From: Caroline Ford
Sent: 13 May 2022 11:42
To: DC Support
Subject: FW: 21/01630/OUT - Land at North West Bicester, Home Farm, Lower Farm and SGR2, Caversfield

From: Tim Screen <Tim.Screen@Cherwell-DC.gov.uk>
Sent: 12 May 2022 17:25
To: Caroline Ford <Caroline.Ford@Cherwell-DC.gov.uk>
Subject: 21/01630/OUT - Land at North West Bicester, Home Farm, Lower Farm and SGR2, Caversfield

LVIA

Play Area Flood Risk

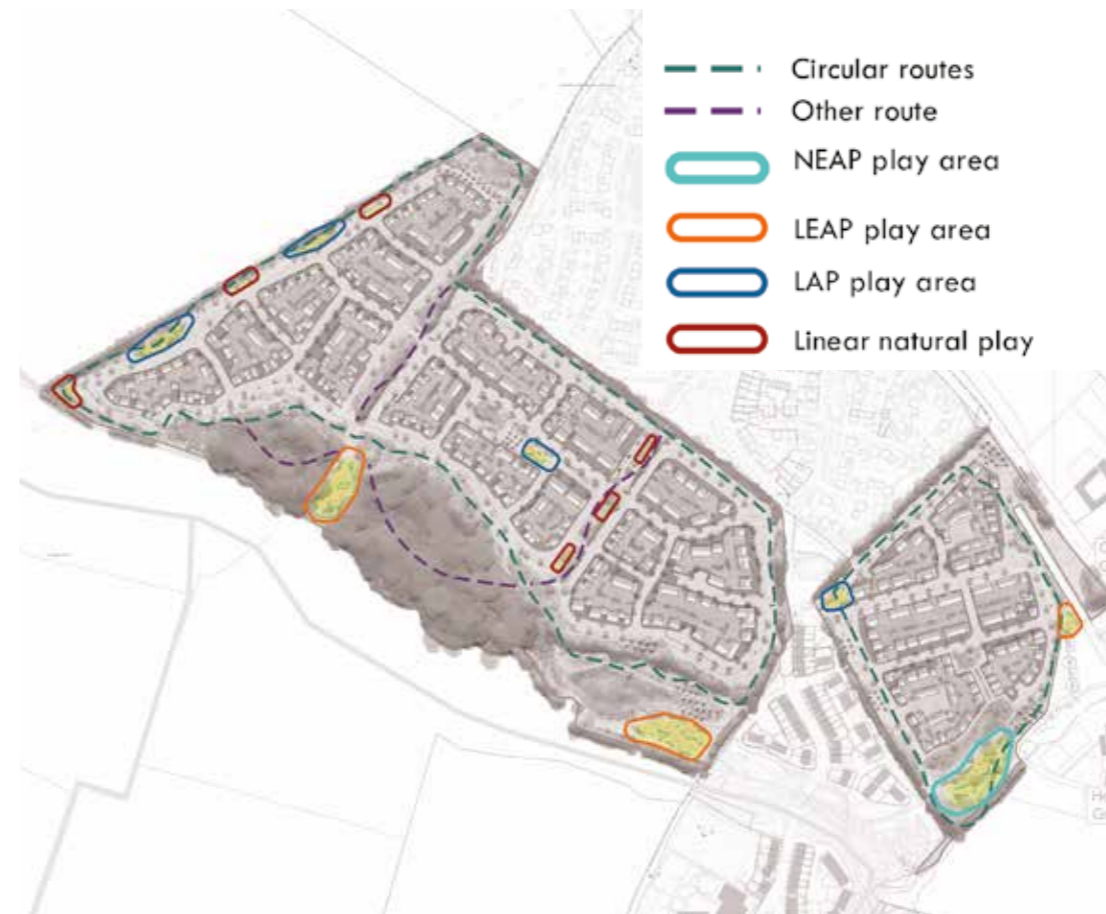
As discussed, in respect of play area ref. 04 far southern extremity of the western parcel shown on the illustrative masterplan, it appears that the play area may be subject to flooding in 1:1000 event - refer to Flood Risk Assessment. As such events become more prevalent, this will mean the play area is unusable, a risk to children's health, and subject to cleaning and repairs before it is ready for to be used again. The play area should be relocated away from the flood zone to avoid these problems.

530 residential dwellings triggers, in accordance with the above policy, LAPs, LEAPs, NEAPs and MUGA. The LAP and LEAP are to be located 400 m from the farthest extent of dwellings. The NEAP and MUGA 1200 m from the farthest dwelling. There is already a MUGA built in phase 2 of the Exemplar which is within 1200 m walking distance. It is deemed unnecessary to have another MUGA because this complies with the original Ecotown Masterplan. The play areas within the western parcel meet the 400 m walking requirement and 3 play area locations are appropriate except for the play area location which may flood – refer above – this play area should be relocated.

The 2 play areas in the eastern parcel is also within the 400 m walking distance requirement. The southern-most play area should be a NEAP for older children and this will be within the 1200 m for dwelling on the extremity i.e. the western parcel.

The western parcel's central square play area is a LAP close to housing for accessibility for 2 - 6 years, parents and carers and allow for good surveillance.

The play area in the woodland is not covered by adequate surveillance. This play area may have a social behavioural problem associated with it, especially if the older children are unaccompanied by adults. I recommend an enhanced LEAP with additional area and challenging play equipment for 4 to 8 year old children within an area of 400 + sq metres of play activity, depending of the landscape context.

The western play area near the 'new' structural landscape/site boundary should be a LEAP to ensure the provision for 4 to 8 year olds.
